**From:** Denise Galle <DGalle@tweed.nsw.gov.au>  
**Sent:** Friday, 11 November 2016 4:45 PM  
**To:** Jenny – Secretary to Darryl Anderson  
**Cc:** Vince Connell; Lindsay McGavin; Ray Clark; Danny Rose  
**Subject:** RE: Land and Environment Court Appeal No. 2016/178476 – Major Project Approval No. 08-0194 Modification No. 3 Kings Forest, Precinct 1 Service Station and Fast Food/Drinks Outlet  
**Attachments:** KFOR Letter to TSC re Condition 27 - 13 October 2016.pdf; Kings Forest Intersection Assessment.pdf; Mortons Tweed Coast Road Plan.pdf; Place Landscape Statement of Intent.pdf; Traffic Impact Assessment reduced.pdf; TSC Response.pdf

Council's Traffic Engineer has reviewed this matter as per your request (having regard to Condition 27 of the MP08\_0194) and can advise as follows:

**Subject:** Land and Environment Court Appeal No. 2016/178476 – Major Project Approval No. 08-0194 Modification No. 3 Kings Forest, Precinct 1 Service Station and Fast Food/Drinks Outlet

Figure 3.3: 2026 Volumes

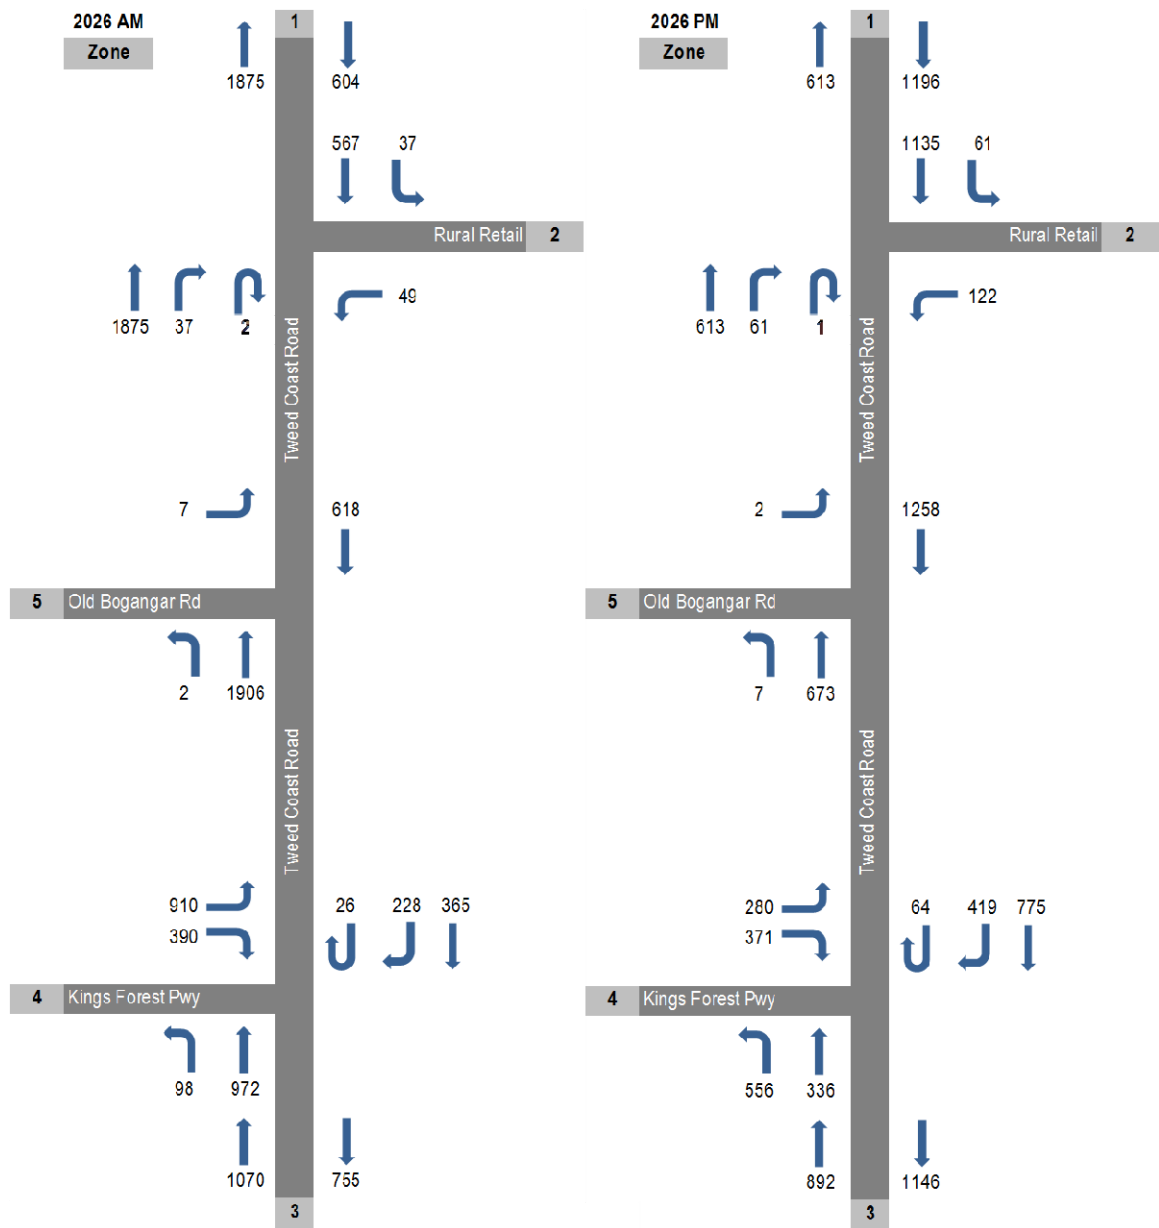
- 2026 modelling showed that Tweed Coast Road northbound lanes needed to be extended to north of the Service Station access and Kings Forest parkway on approach to the TCRd rounded need to be extended to allow for additional queuing (Figure 3.6)
- AIMSUM traffic modelling indicates limited impact on road network
- Design complies with Austroads Guide to Road Design Part 4a Unsignalised and Signalised Intersections
- Proposed parking compliant with DCP A2 and AS2890

- Tweed Coast Road and Kings Forest parkway are to be constructed to the required 2026 configuration
- Pedestrian connectivity is to be provided to the existing refuge on both sides of Tweed Coast Road.
- Sensitivity analysis should be carried out reducing cumulative trip reduction for multiuse.

Figure 5.4: Tweed Coast Road / Kings Forest Parkway Intersection

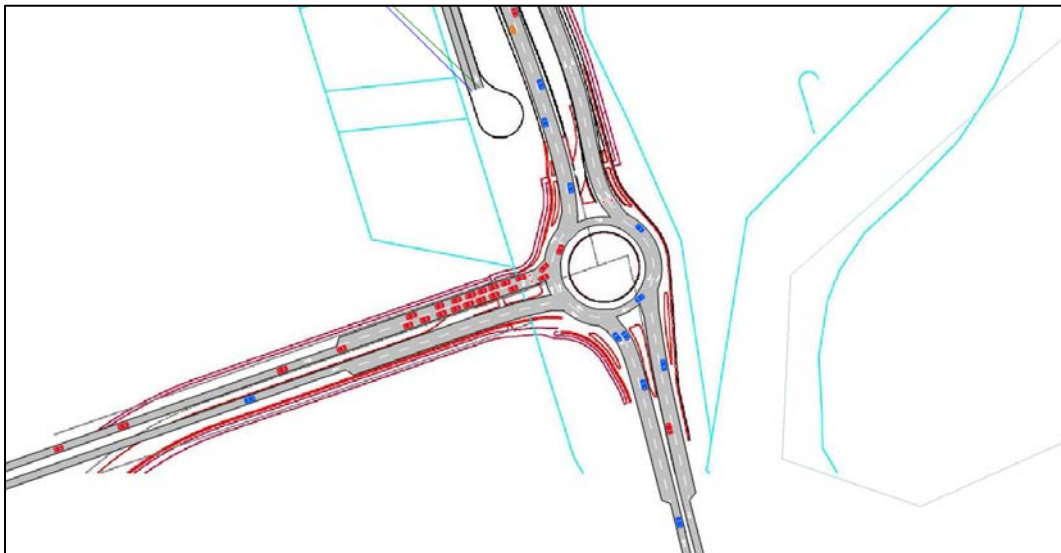
- The previous Rural Retail site was modelled on 122 AM trips and 244 PM trips with a single entry and exit point.
- Proposed are a Petrol/Convenience Store (180m<sup>2</sup>) and Tenancies and Eating Area (760m<sup>2</sup>) with separate entry exit access. The exit is restricted to left out only. Northbound vehicles will need to carry out a U-turn at the proposed roundabout.
